28th July 2013

A/74/13 Proposed planning application for distribution warehouse and covered storage, trade counter and associated offices for Fargro at The Vineries, Poling.

Fig 1. Map showing the location of customers spending more than £1000 pa with Fargro. The area of distribution is wide but there is a marked concentration in the Arun area.

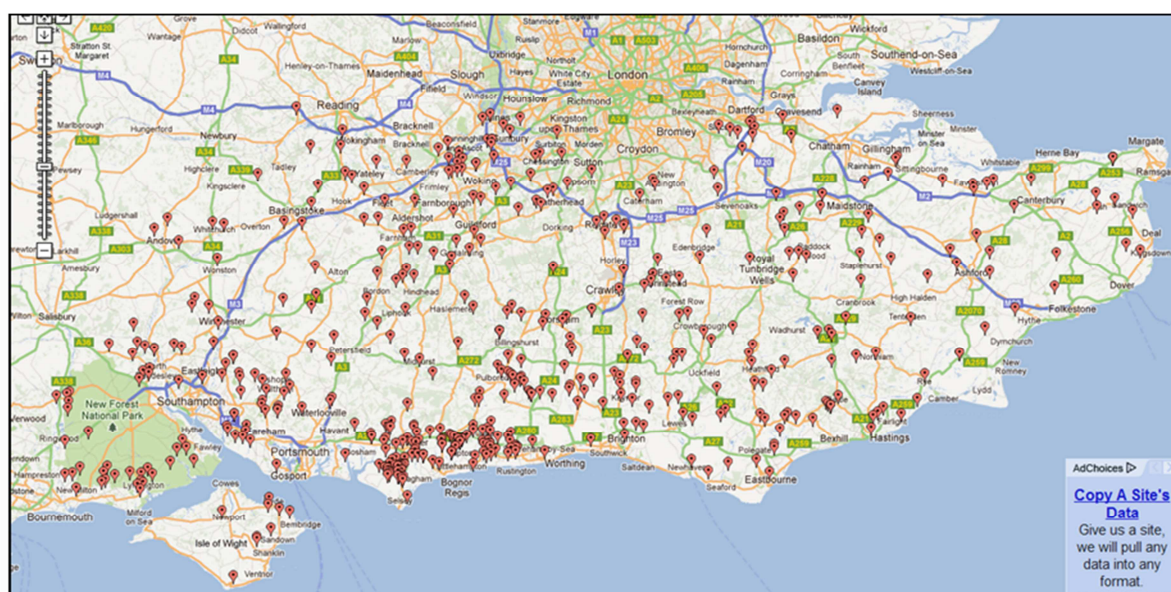
6. In reference to the Fargo assessment of alternative sites for relocation from their present site at Toddington. Page 6 Fig 1 re distribution map. Although Fargo have looked at alternative sites, they haven't looked at other sites further than the Arun area. Their distribution covers a large area of southeast England and they have taken a very simplistic attitude by not looking further afield. There is no consideration given to moving to a more central area within their distribution location and relocating their valuable staff. This would give their business an opportunity to extend and perhaps expand. Just to say "*this is where we are and this is where we wish to stay*" is not a sufficient argument for moving to an open green field site at The Vineries.
